TfNSW reference: WST24/00264/002 | SF2024/125016
Your reference: SSD-9619 (PAE-77334994)

SSD-9619 Modification 1 – Tilbuster Solar Farm – TfNSW response

TfNSW has reviewed the Modification Report prepared by Enerparc Australia dated August 2024 and the Traffic Assessment (Appendix D3) prepared by Amber Organisation dated 8 July 2024. TfNSW notes that this modification has changed the development in these key areas:

Figure 1 Development footprint

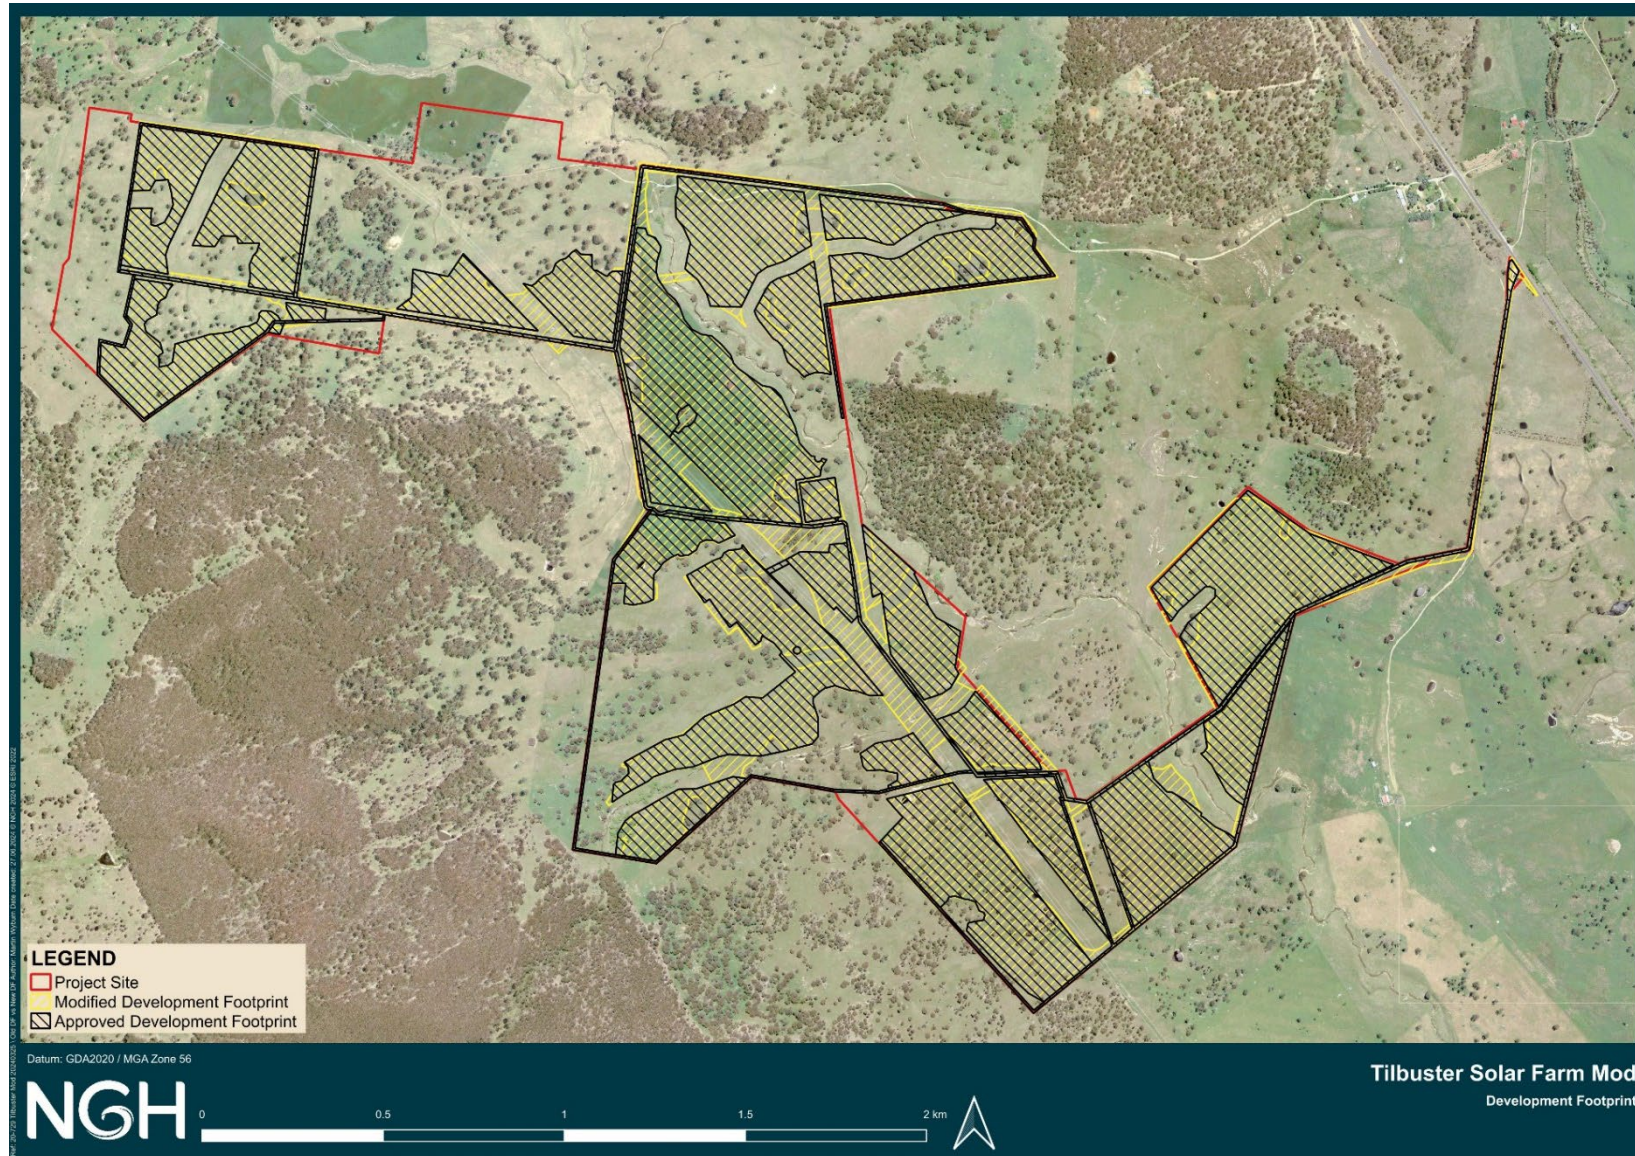
1. TfNSW notes that the development footprint expansion will include access road widening and realignment to the relocated substation. Clarification is sought on where this increased construction footprint is and whether this will have any direct impacts on the New England Highway or road reserve. Noting that any changes to the width must not be contradictory to the approved strategic designs in Appendix 5 for the BAR/BAL and to Condition B5(b) of the Notice of Determination (NoD) dated 3 March 2022, which limits the sealed carriageway to 6.0m and 0.75m (unsealed) shoulders on both sides of the New England Highway.

Figure 2: Proposed Route Port of Newcastle to Site

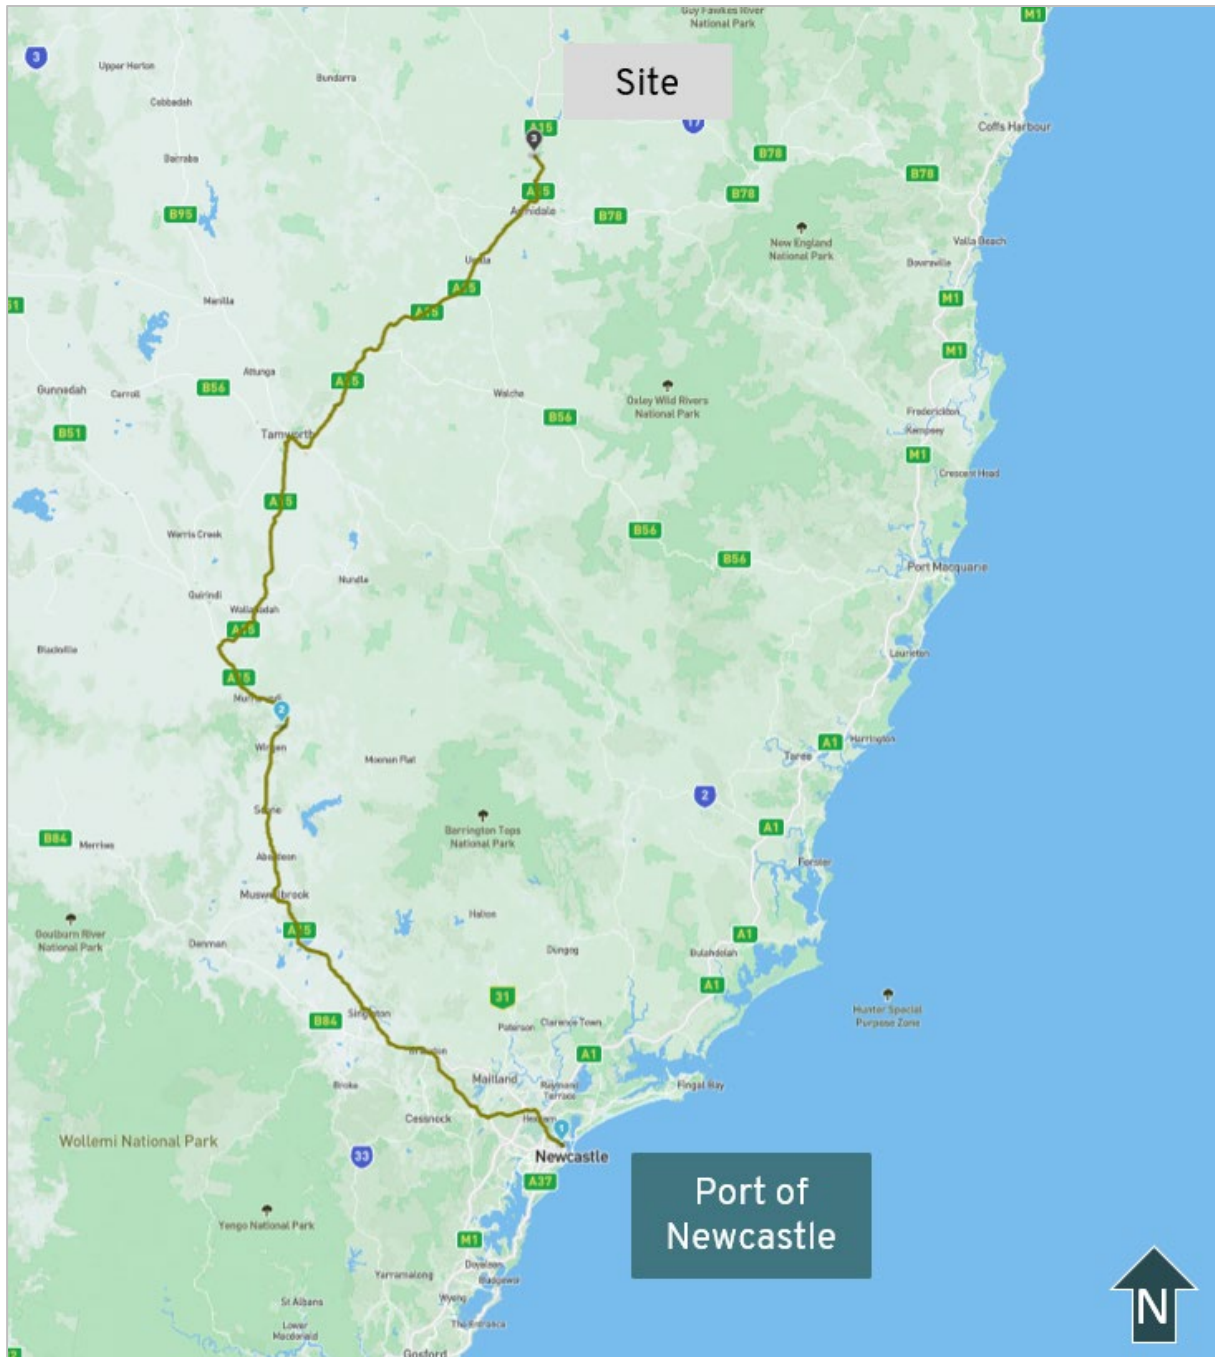
4. TfNSW have no concern with the addition of the Port of Newcastle as an origin destination for the haulage route for all oversize/overmass vehicles (OSOM), if evidence is provided to TfNSW that all OSOM with the laden dimensions and weights (load plus vehicle combinations) conform with the restrictions and limitations identified within the NHVR NSW Class 1 Load Carrying Vehicle Operator's Guide. If the laden dimensions of the OSOM do not conform with the NHVR NSW Class 1 Load Carrying Vehicle Operator's Guide and if one of the dimensions or weights fall for the OSOM

are classed as high risk OSOM (as defined by the TfNSW website), then a concept route analysis will be required to be provided to TfNSW for review as a part of the response to submissions.
